Ribchester Parish Council

PLANNING APPLICATION No: 3/2017/0991

Application: Alternative vehicle access onto Stoneygate Lane.

At: **Park Hey House Stoneygate Lane Ribchester.**

drawing
PROPOSED NEW
ENTRANCE DRIVE

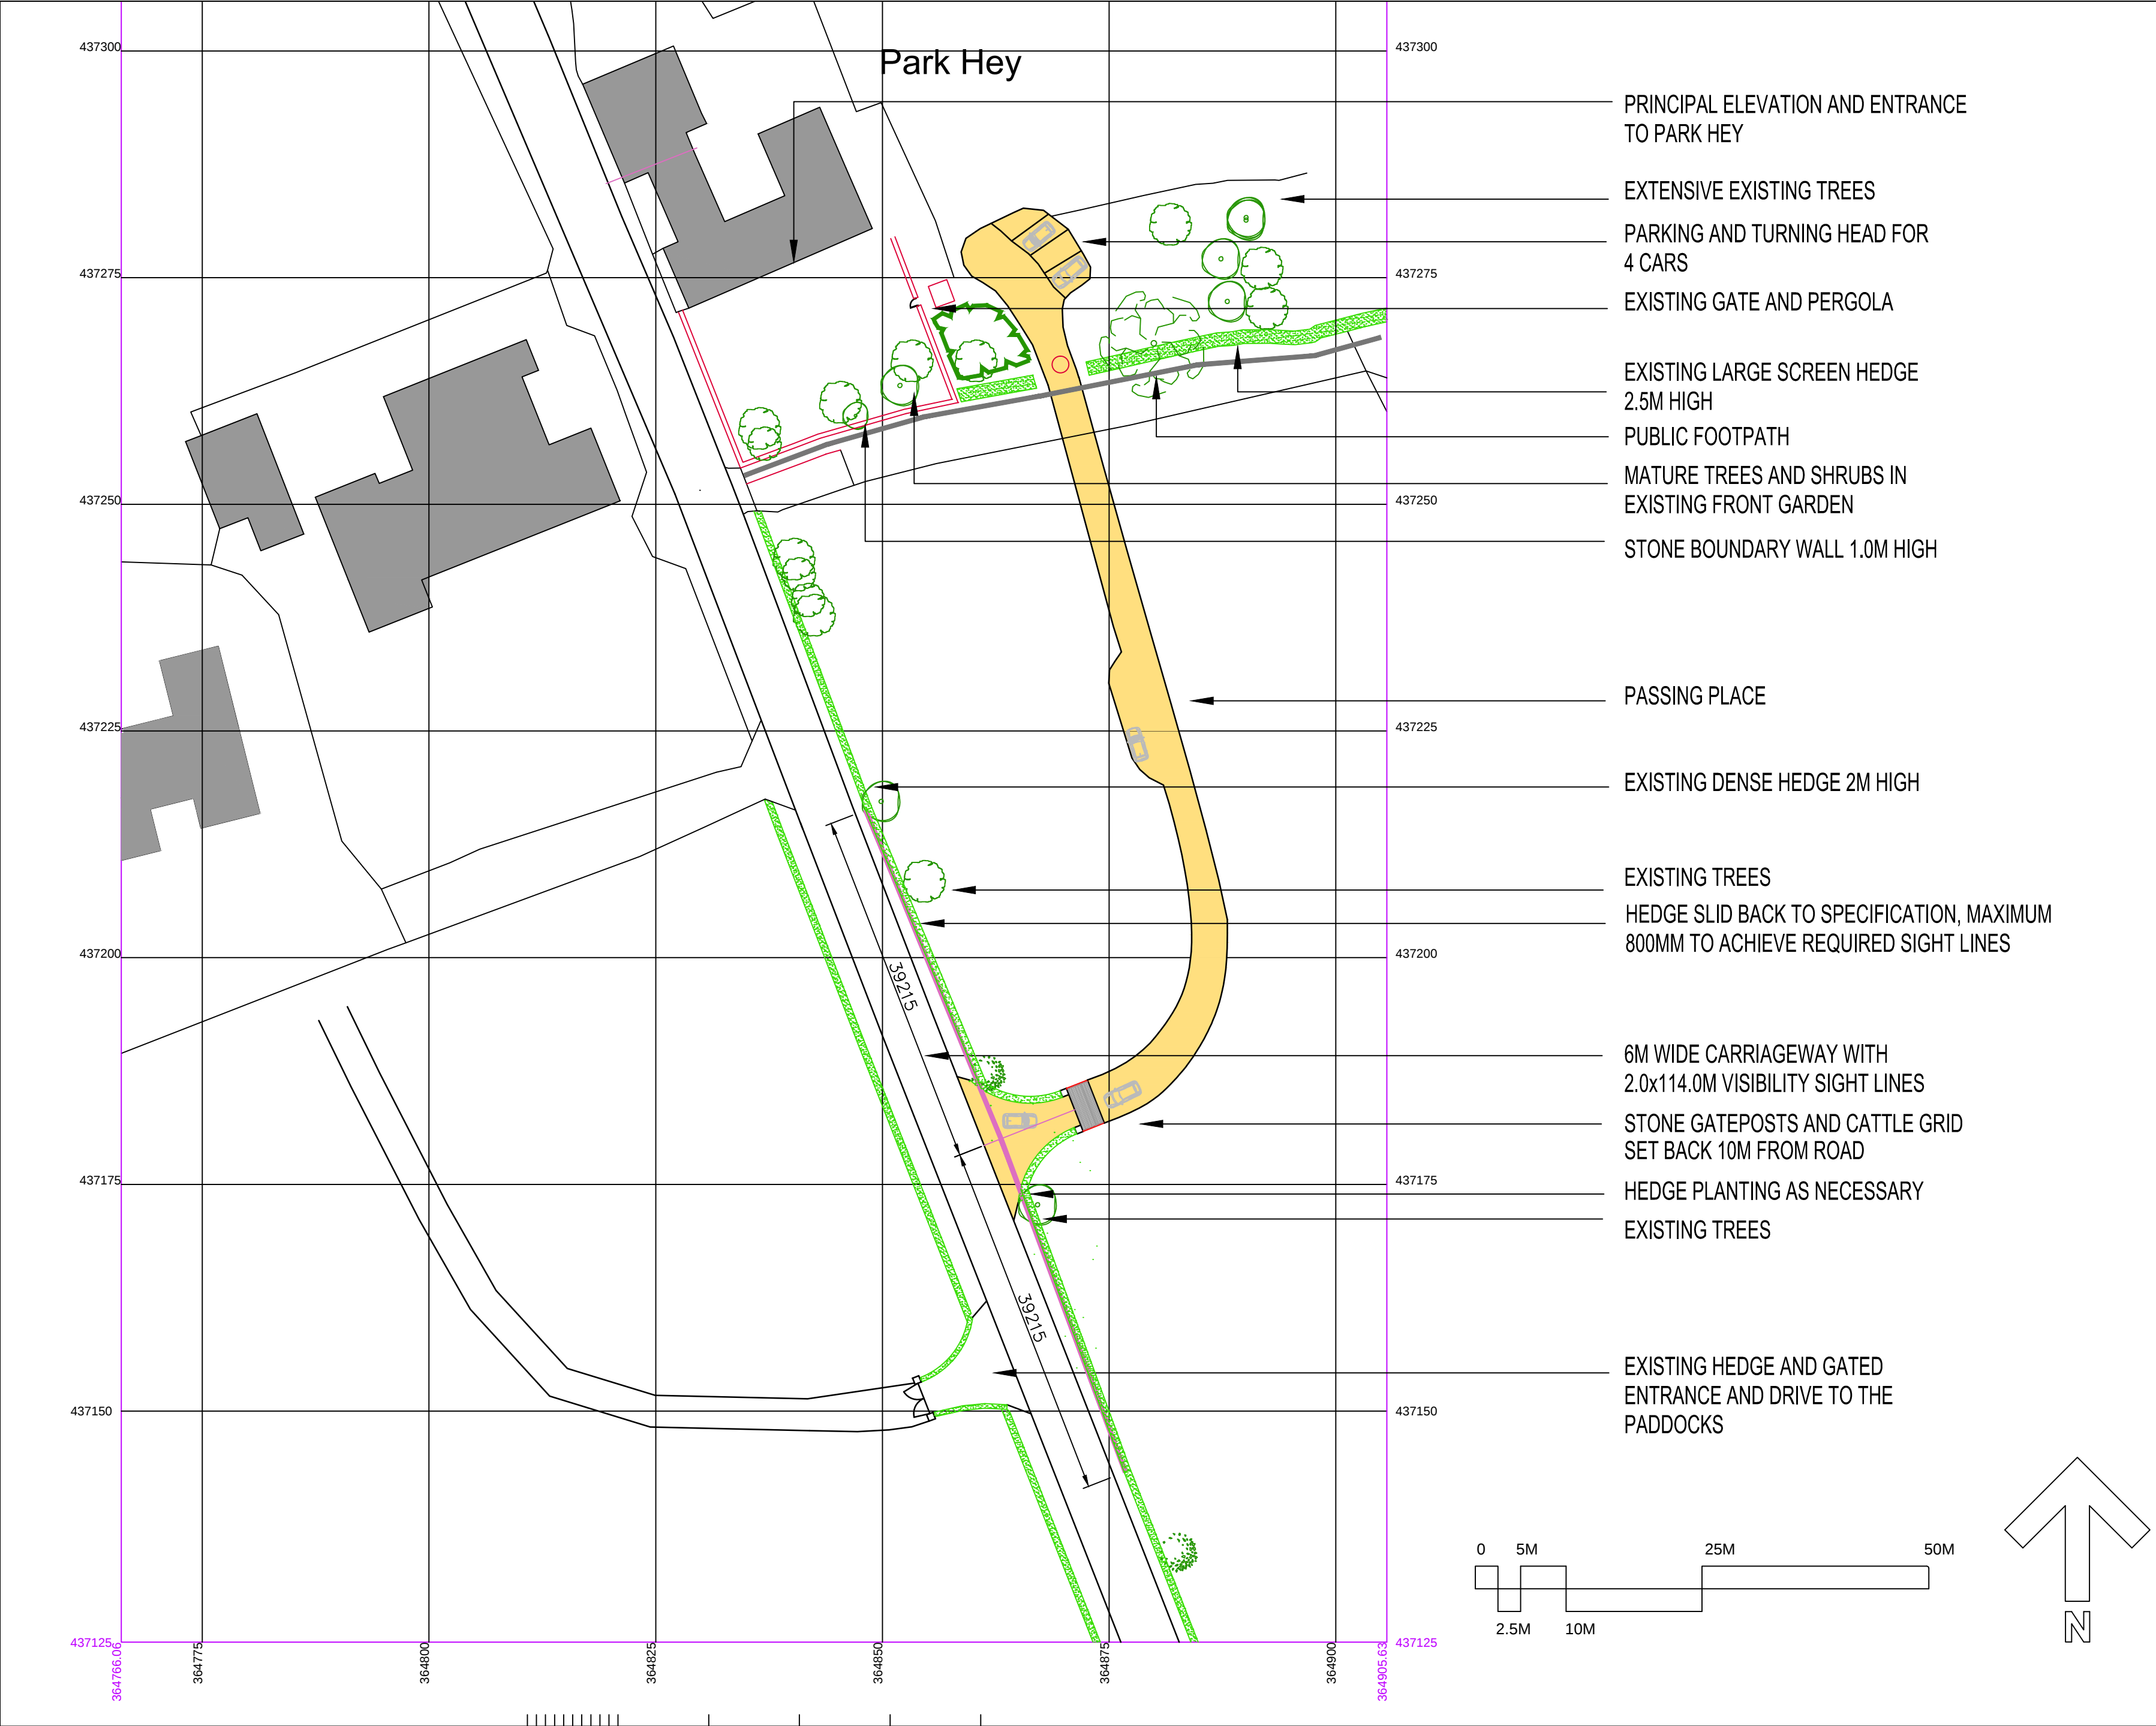
1. Despite the somewhat naive views of the planning Inspector the proposed new development is sited, insensitively, across an open agricultural field which is wholly rural in nature. By so doing it represents an unnecessary encroachment into open countryside leading to an unacceptable harm to the appearance and character of the area,
2. The proposal would effectively entail development and urban encroachment outside the current settlement boundary
